**From:** Plater, Roger - Communities  
**Sent:** 19 June 2020 15:47  
**To:** Matthew Chadwick  
**Subject:** RE: 20-01316-TEL56 Skimmingdish Lane

**From:** Plater, Roger - Communities  
**Sent:** 15 June 2020 12:40  
**To:** Matthew Chadwick  
**Subject:** 20-01316-TEL56 Skimmingdish Lane

Title: 215 PROPOSED SITE PLAN

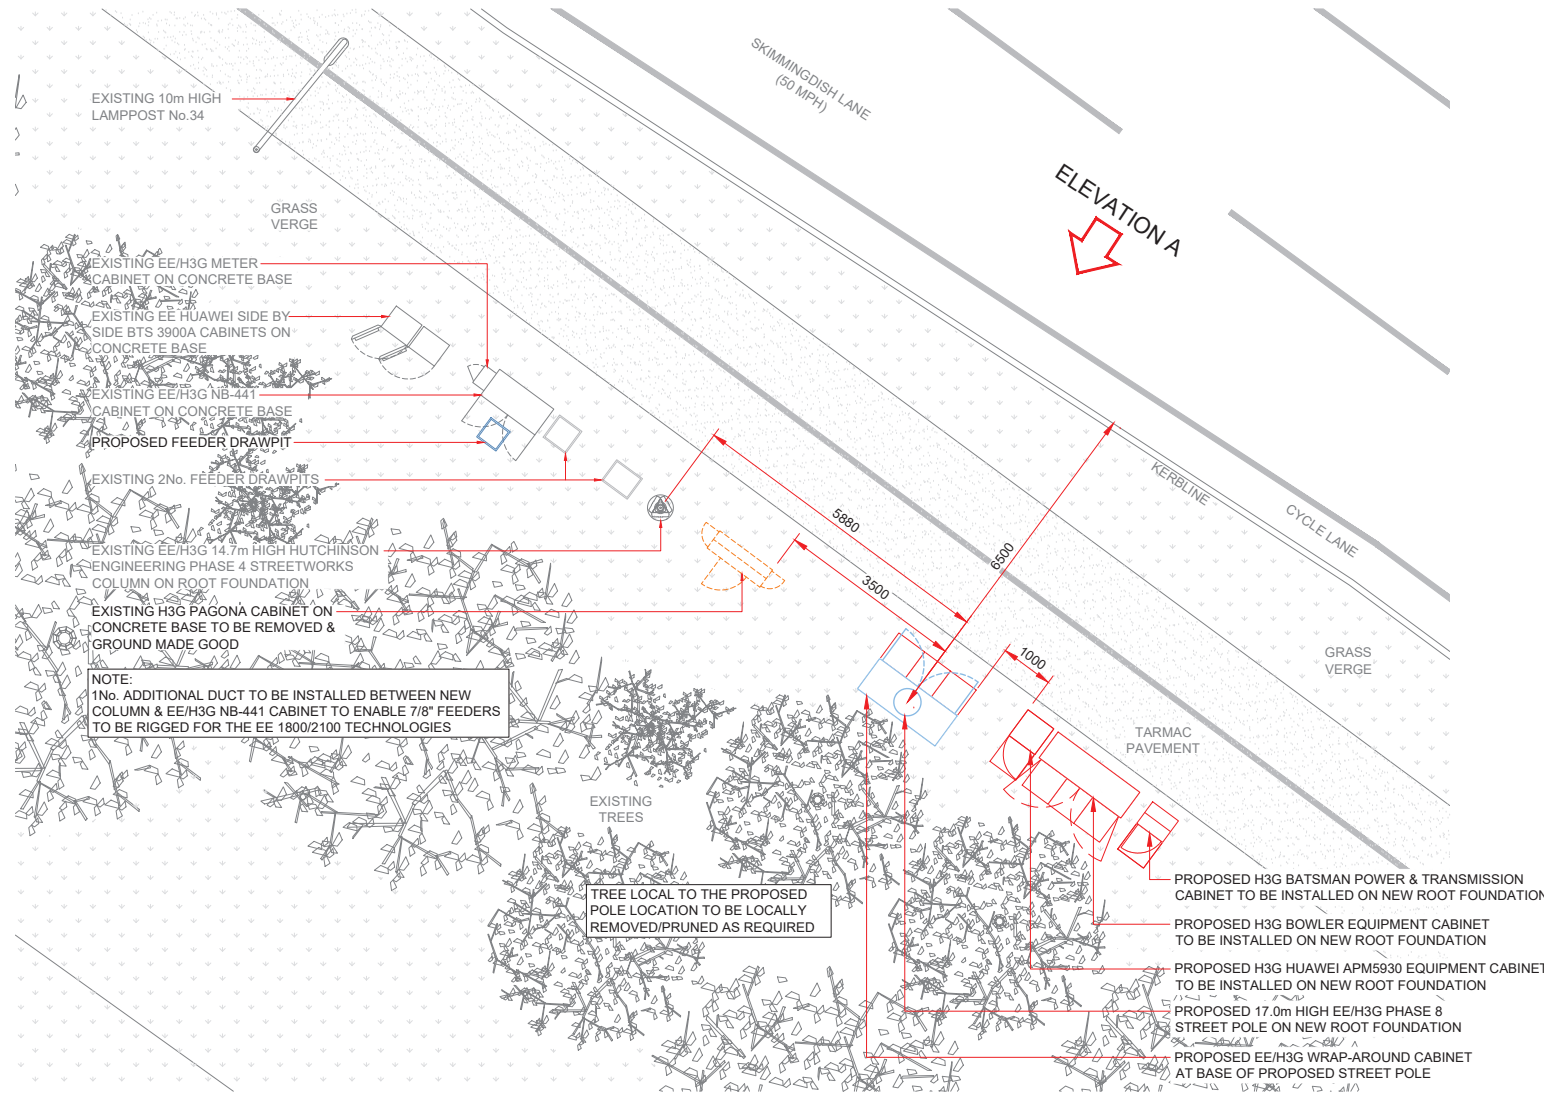
There seem to be a few Plans missing from the portal, so I can't tell exactly where the new mast is to be located as it is not a straight replacement. Unlikely to be an issue as I presume it is close to the existing and well back from the carriageway, but thought that I had better check.
